WILLOWTREE PLANNING

REF: WTJ20-395

Wentworthville Northside West Clinic Extension SSD-17899480

TABLE 1. COUNCIL & AGENCY COMMENTS 21.09.2022		
A.	Cumberland Council Response	Applicant Response
1.	Council maintains the objection to the development application with regard to the proposed breach in the development standards. Council notes that the proposal has attempted to address the issues raised notably by reducing the building height breach from 30.7% to 24.5%. Matters raised in the objection previously submitted however continue to remain.	A comprehensive Clause 4.6 variation was submitted with the RtS which addressed the mandatory components of Clause 4.6, being: 1. Objectives of the standard 2. Objectives of the zone 3. Why the standard is unreasonable and unnecessary 4. Environmental planning grounds for the variation All of the above have been addressed satisfactorily which demonstrate the variation is supportable and justified, having regard to the site conditions, nature of the use, surrounding land use and resultant impacts.

This design complies with: AS3500.3:2021	NORTHSIDE WEST CLINIC			
	PIPE LAYOUT - GROUND FLOOR			
	Size A3	Status APPROVED FOR SUBMISSION	Drwg No. DR-101	Rev. 3

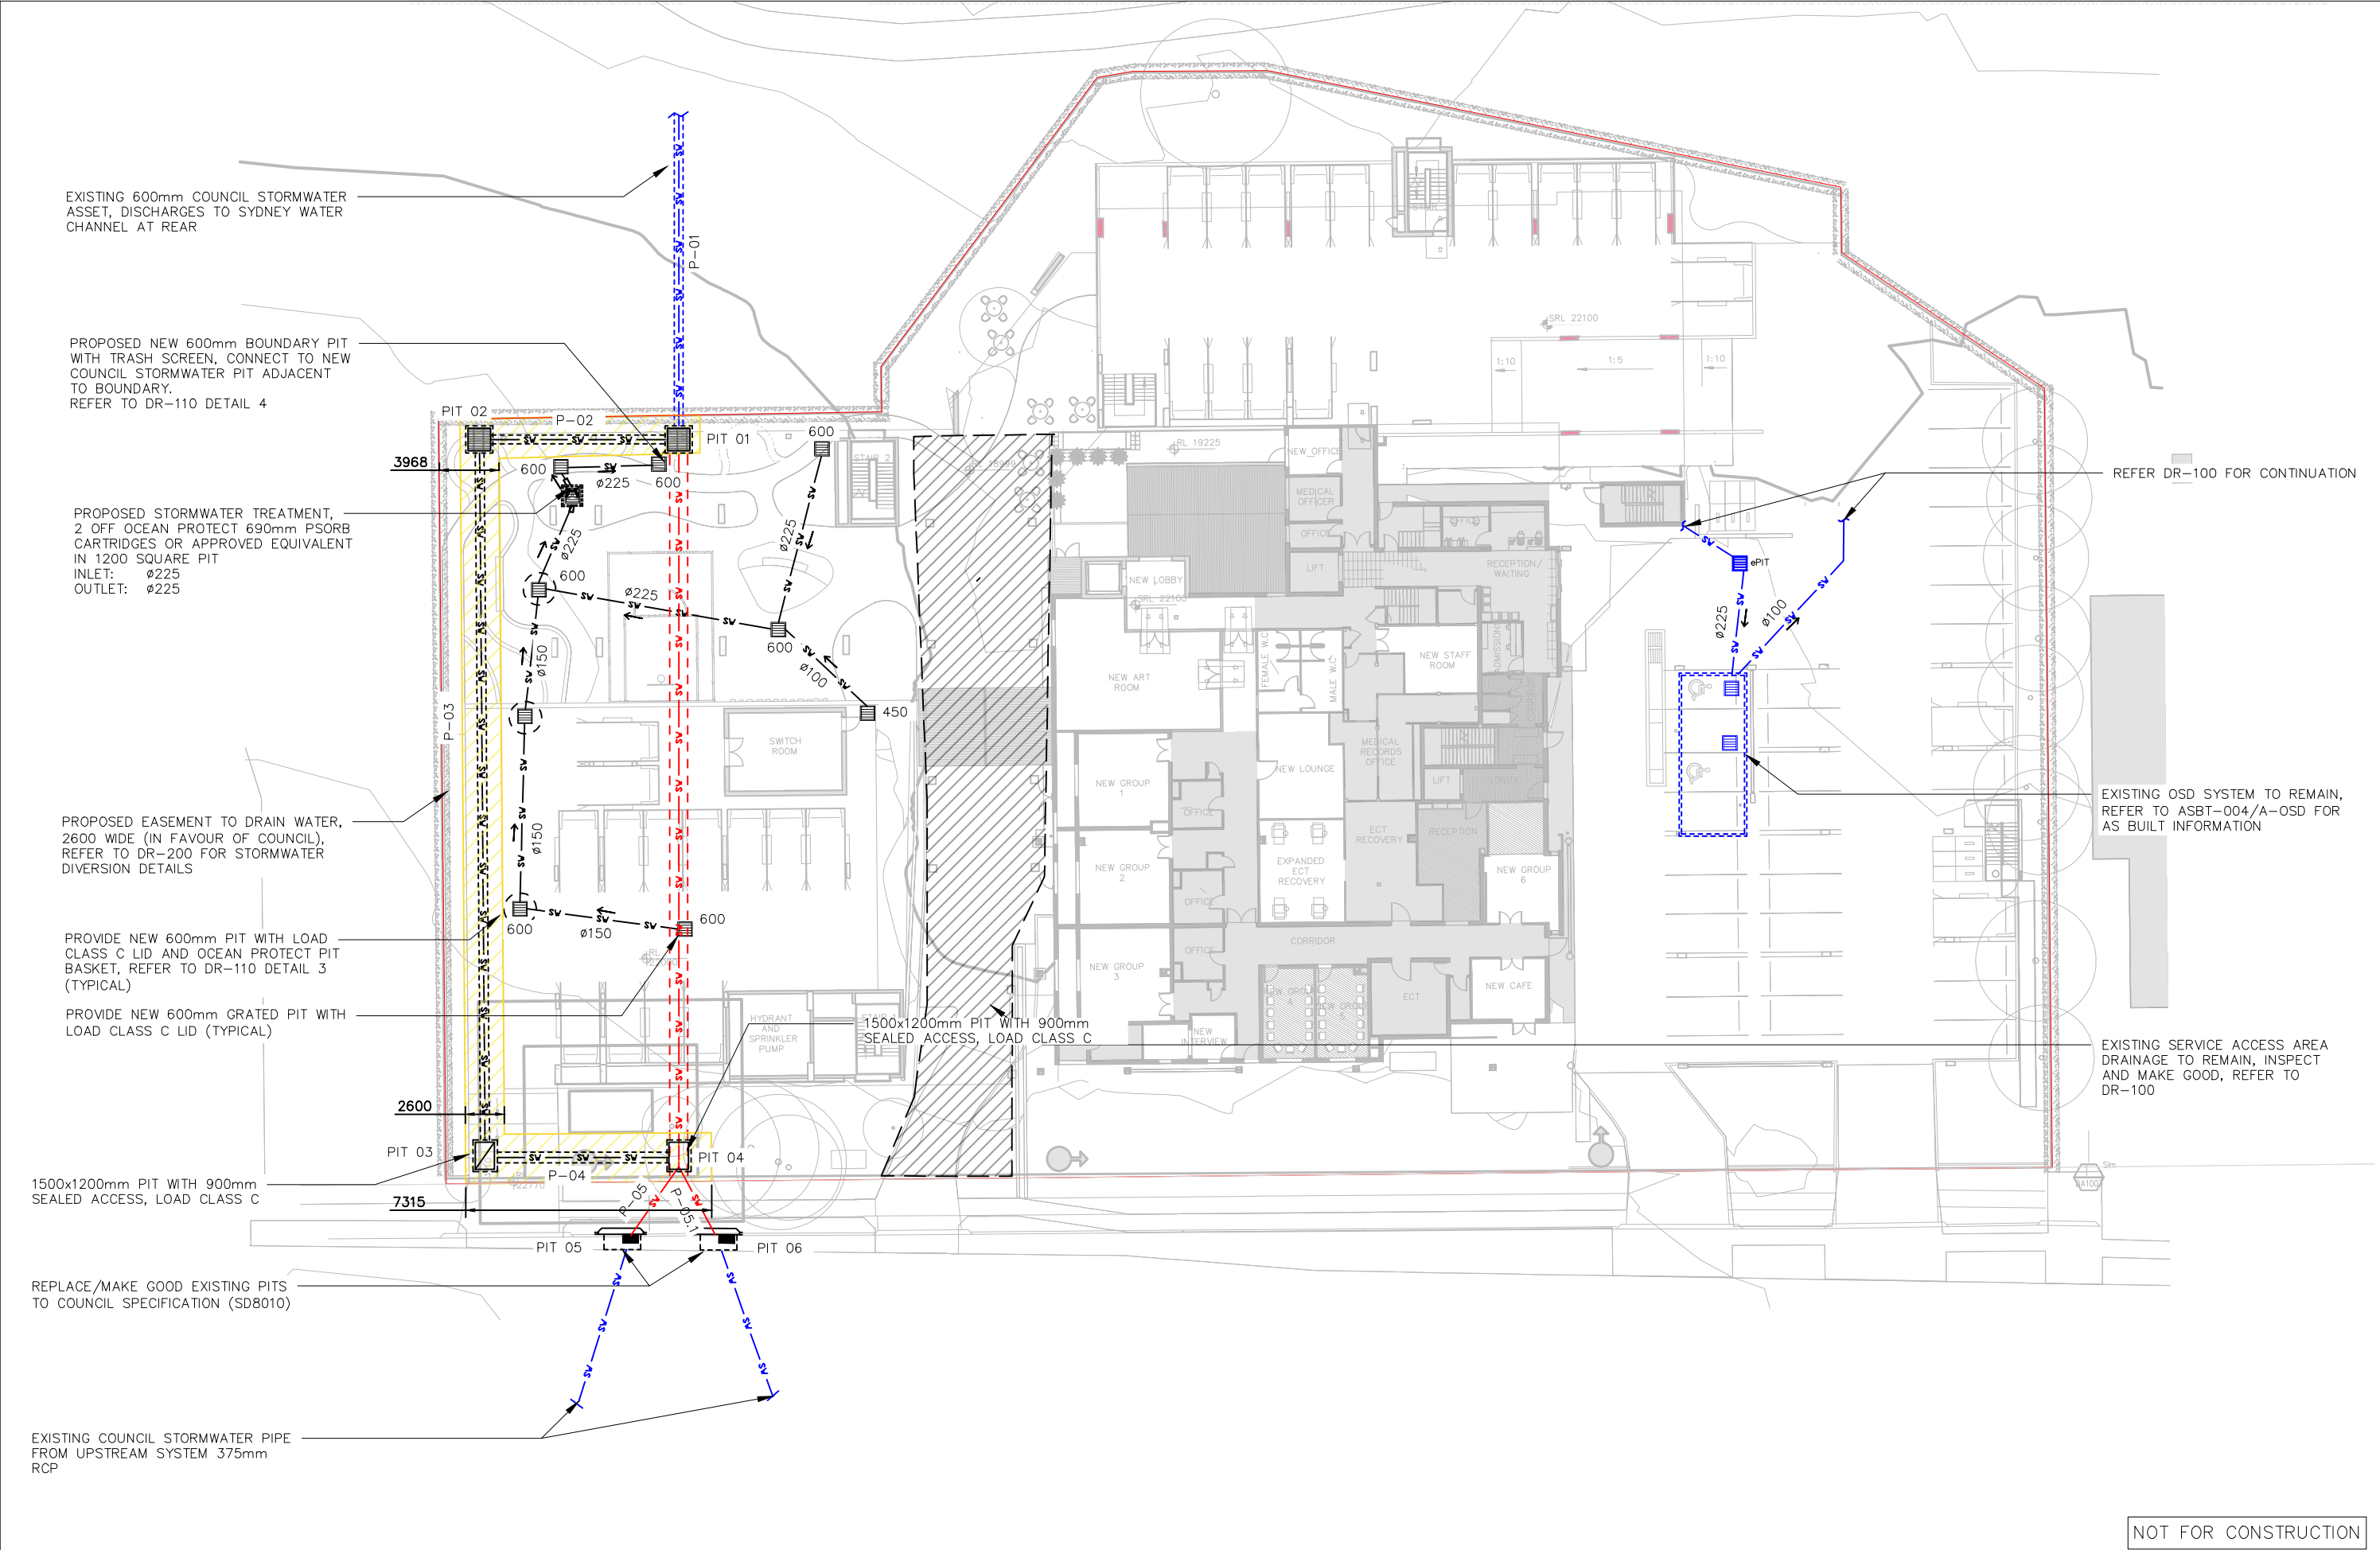
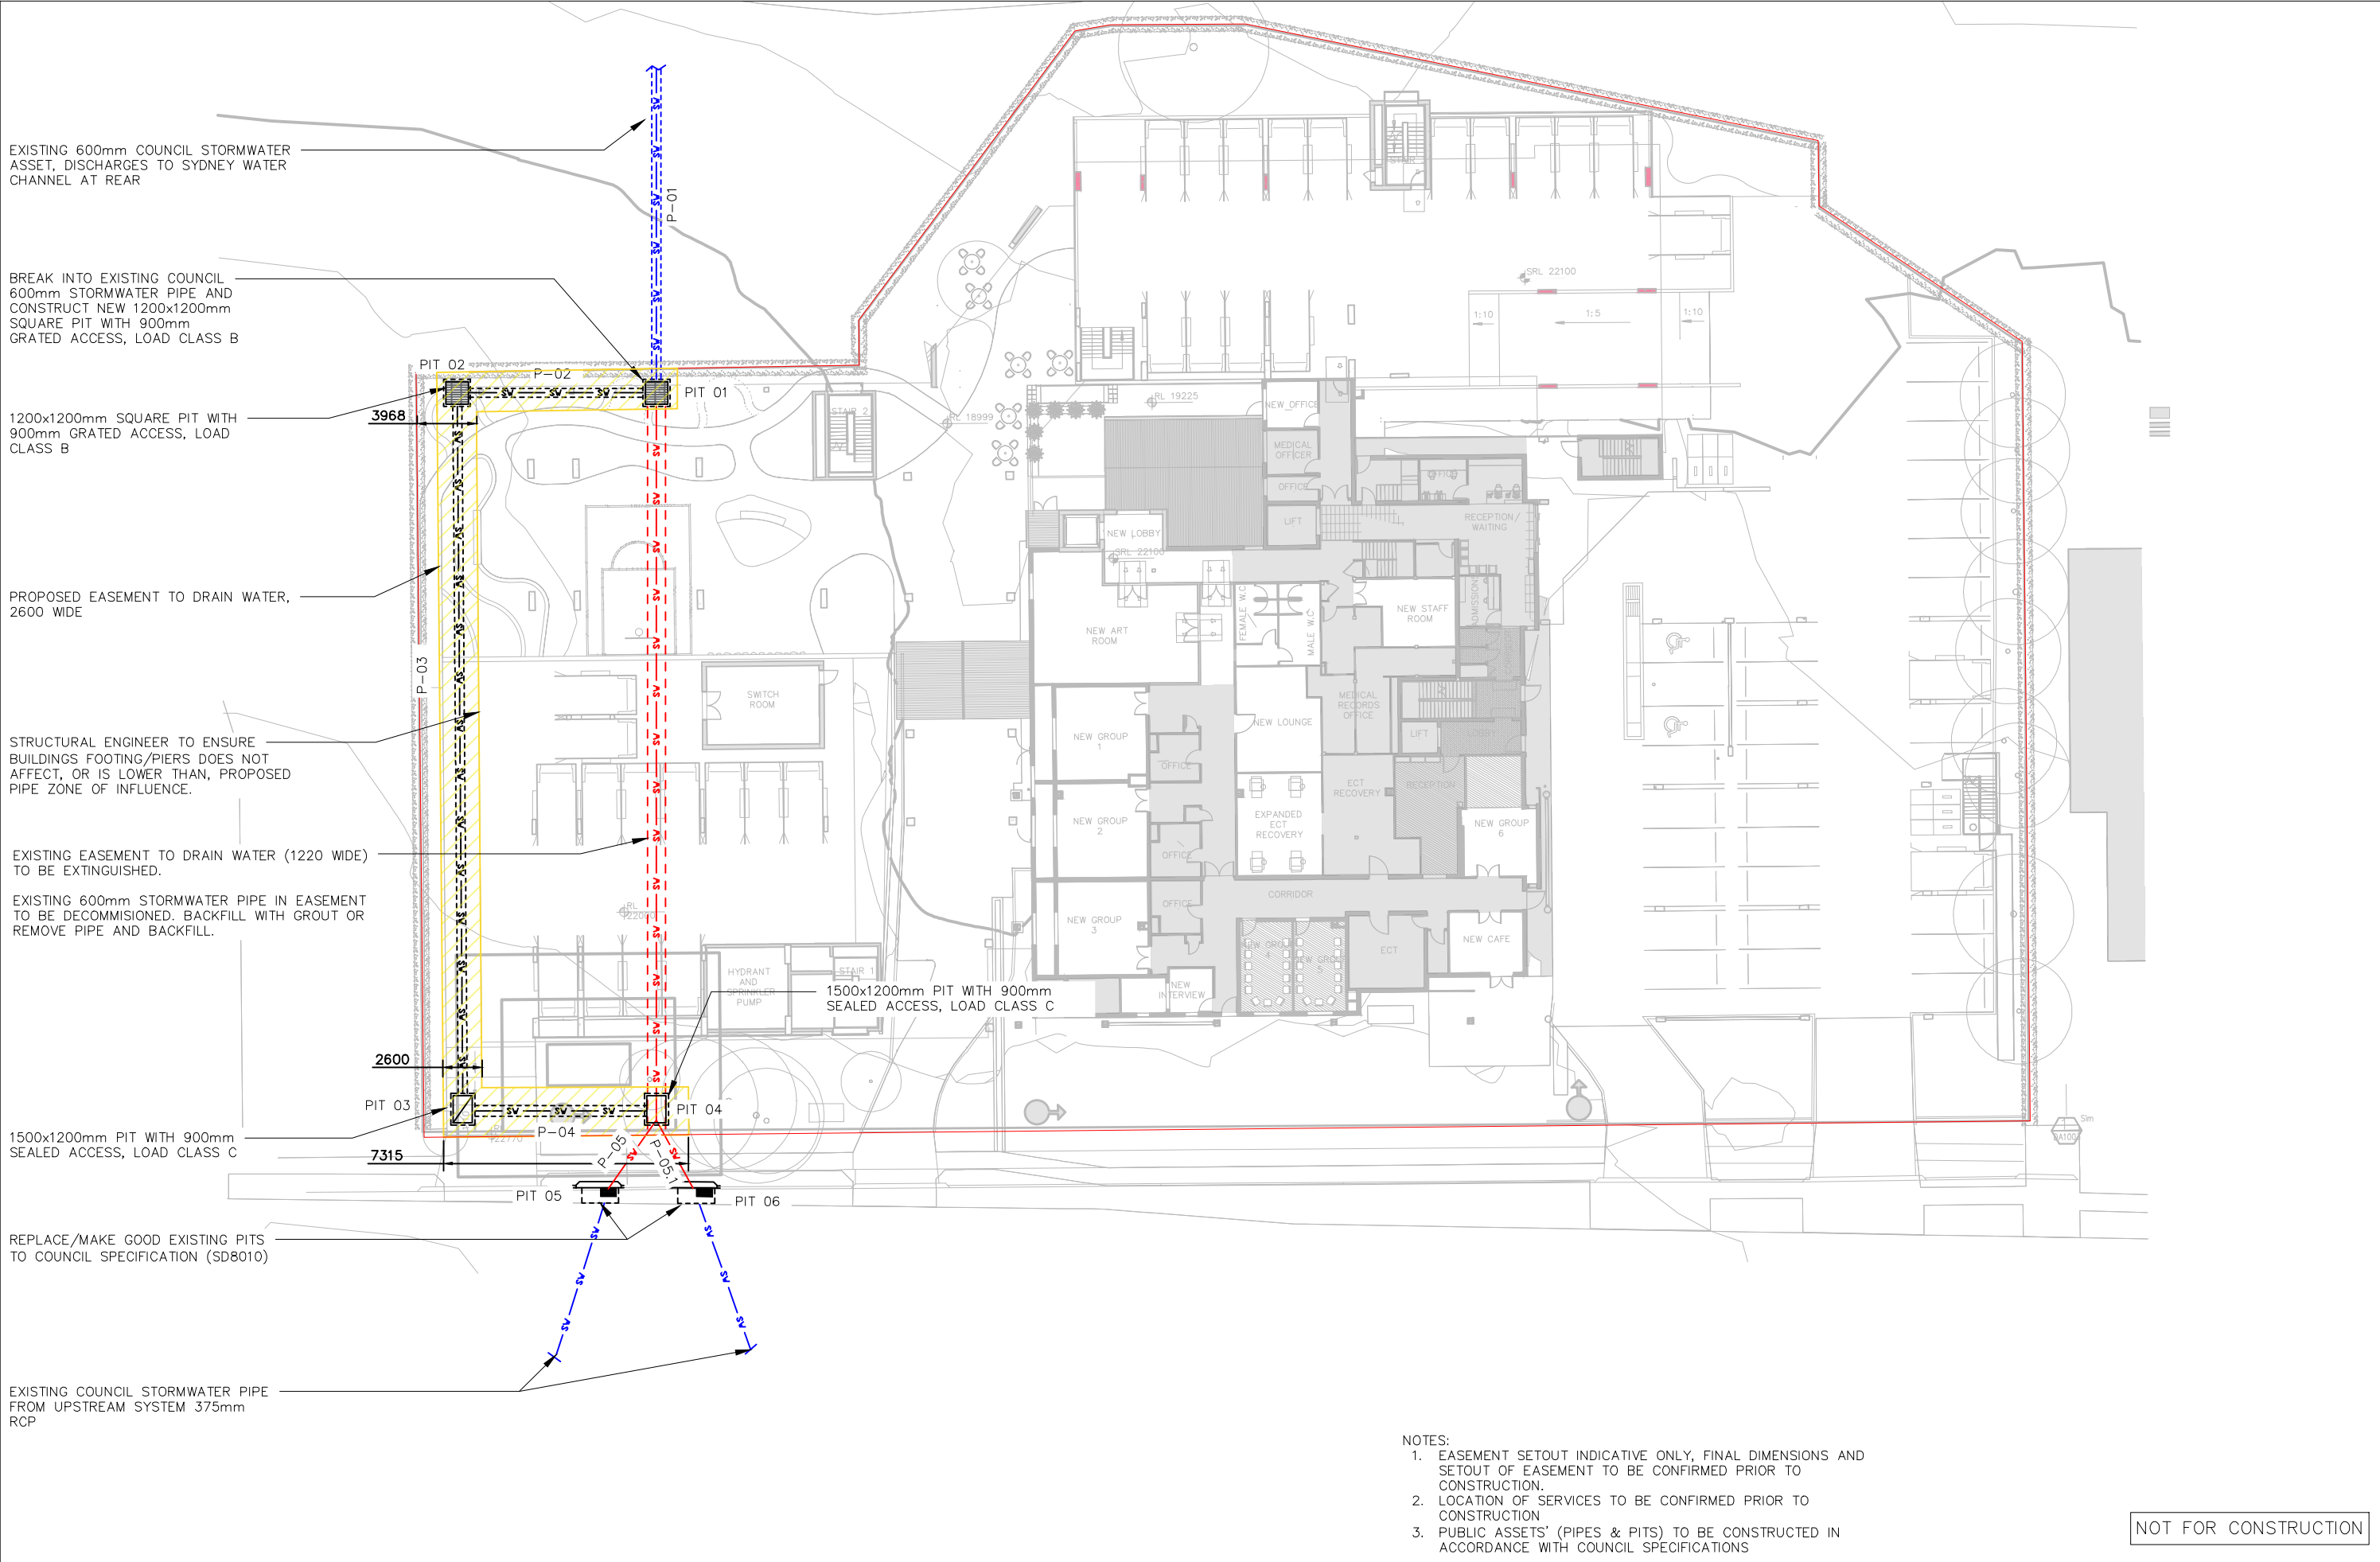
5.	Council Pipeline/Easement A minimum of 5.6 metres vertical clearance stated on the stormwater letter prepared by Stellen Consulting dated 8 June 2022 over the Council's stormwater pipe and/or associated easements shall be indicated and annotated on the architectural plans to ensure that the minimum clearance proposed is achieved.	Noted and to be completed.
